Caroline Ford, Senior Planning Officer  
Cherwell District Council  
Bodicote House  
Bodicote  
Banbury OX15 4AA

December 7<sup>th</sup> 2021

**Ref: 21/03558/OUT – Land north of Gavray Drive, Bicester. Residential development for up to 250 dwellings including affordable housing and ancillary uses including retained Local Wildlife Site, public open space, play areas, localised land remodelling, compensatory flood storage, structural planting and access.**

(see Drawing No. 239\_P11-Access & Movement Parameter Plan)

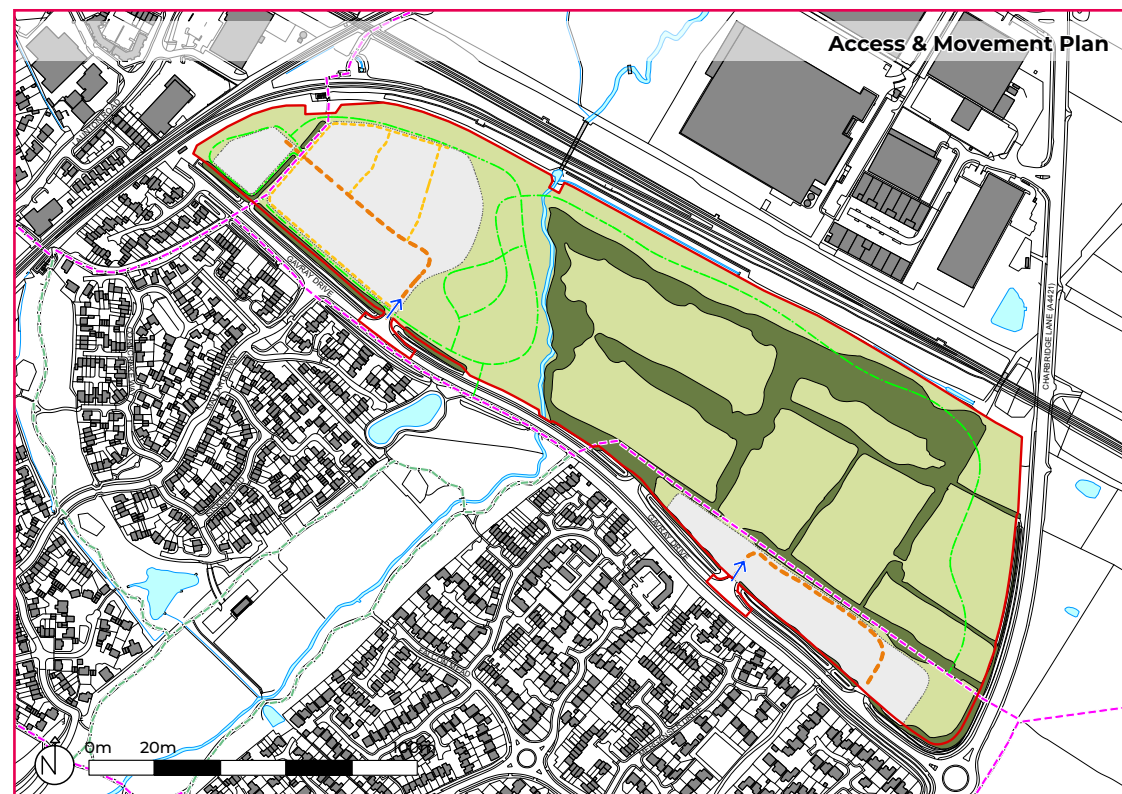
In order to increase the protection of the LWS/CTA, a buffer of undeveloped land is needed between the houses planned along Gavray Drive and the LWS. Reduction in the pressure on wildlife due to the increased human population living in proximity is important. Factors due to the new housing such as noise, light and household pets will have a detrimental effect on the resident wildlife. The outline plans show that the access

road for the houses along Gavray Drive will be constructed north of the houses in the buffer zone and the street lighting for that may have a detrimental effect on resident bats that are recorded in the ancient hedgerow.

(see Drawing No. 239\_P13-Density Parameter Plan)

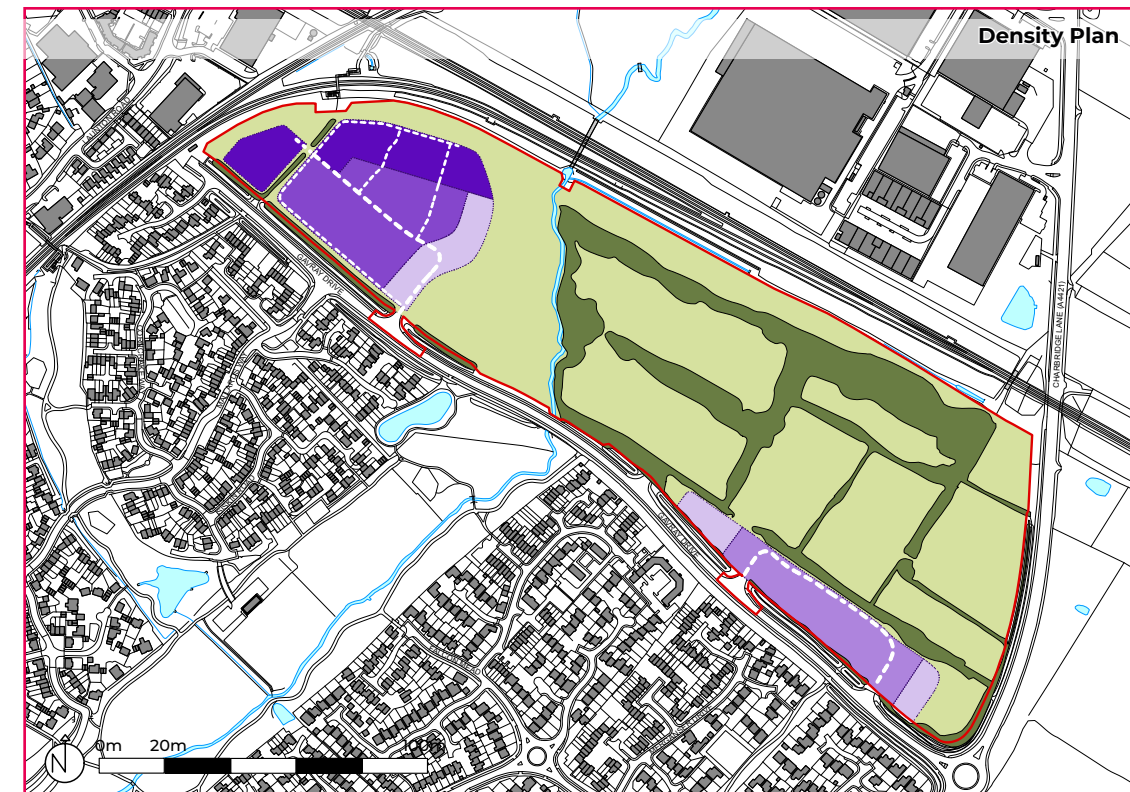
CPRE supports a policy of building at housing densities of greater than 40dph for efficient land use especially when farmland will be lost to built development. Thus the suggestion to build some apartment blocks for smaller households rather than individual houses nearer the western (railway) end of the site is supported.

Housing east of Langford brook along Gavray Drive is more problematical because of the proximity to the designated nature areas. CPRE would support a greater density of housing on the west site in order to further reduce the number of dwellings along Gavray Drive to the east of Langford Brook.
